Application No: P/124/25/PL

Site Address: Land to East of Commonmead Barn Pagham Road Pagham PO21 3PY

Description of works: 2 No single storey detached dwellings (with accommodation in the roof space) along with associated car and cycle parking (resubmission following P/9/24/PL). This application is a Departure from the Development Plan and is in CIL Zone 5 and is CIL Liable as new dwellings.

Thank you for your internet representation made on 17th October 2025 which has been recorded as an objection with the comments as follows:

Drawing Title:  
**PROPOSED BLOCK PLAN**

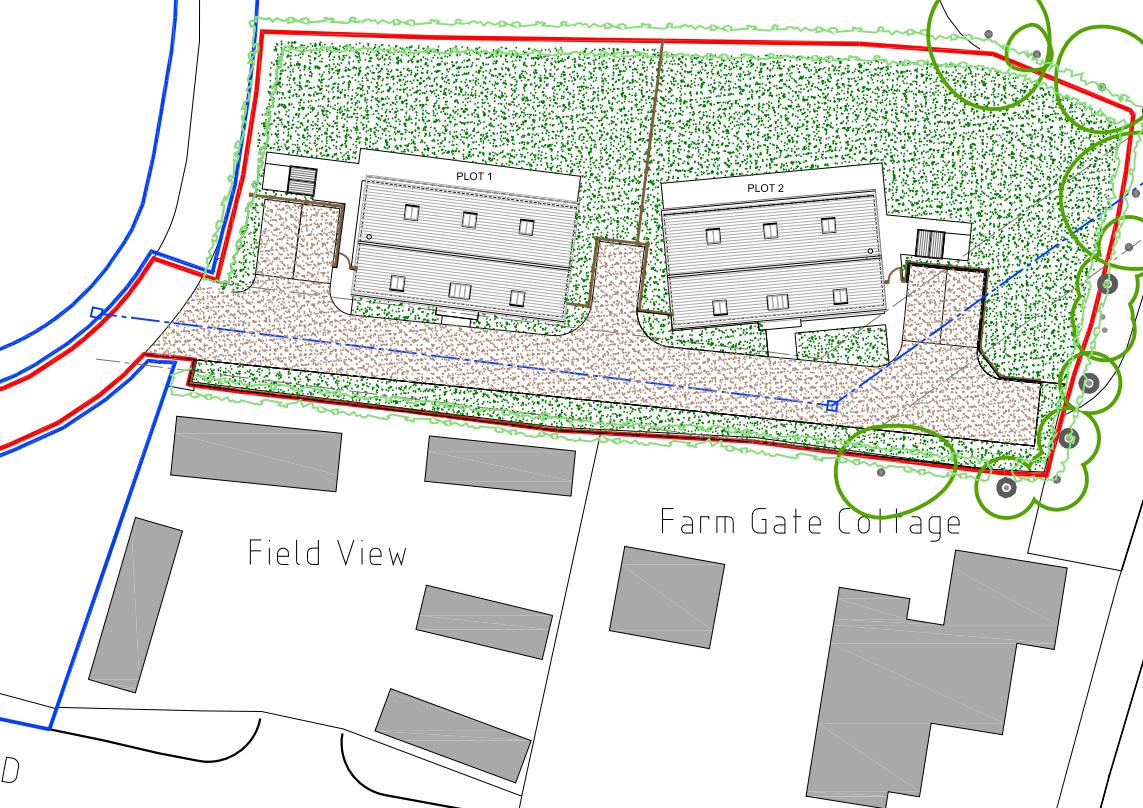
The "SUDS and draining report P2" sets out how "the foul water will be treated on site via a new package treatment plant; all treated effluent runoff will be discharged into the existing watercourse" and also makes the claim that "The existing culvert and watercourse are within the client's ownership".

What can be seen from the map however is that the source of the watercourse is our pond, and the culvert

acts as a flood prevention overflow for the pond. We are also the land owners of the watercourse further downstream (once it leaves the applicant's land).

After a history of flooding issues on this site, the applicant and the previous owners of Rookery Farm agreed an easement by which the pond within Rookery Farm is able to drain via a drainpipe going through the application site. This is vital to manage flood risk both at Rookery Farm and on the applicant site.

Clearly using this watercourse (for anything) increases the flood risk on our property and using the watercourse for foul waste creates a significant risk of pollution for our pond. This can't be allowed surely? I thought foul waste discharges to ponds was not permitted? We will also not grant Ordinary Watercourse Consent for this. I also don't see the impact of discharging treated foul water taken into consideration in the Ecological Impact Assessment or BNG metric. Are there any pollution prevention measures to be implemented?
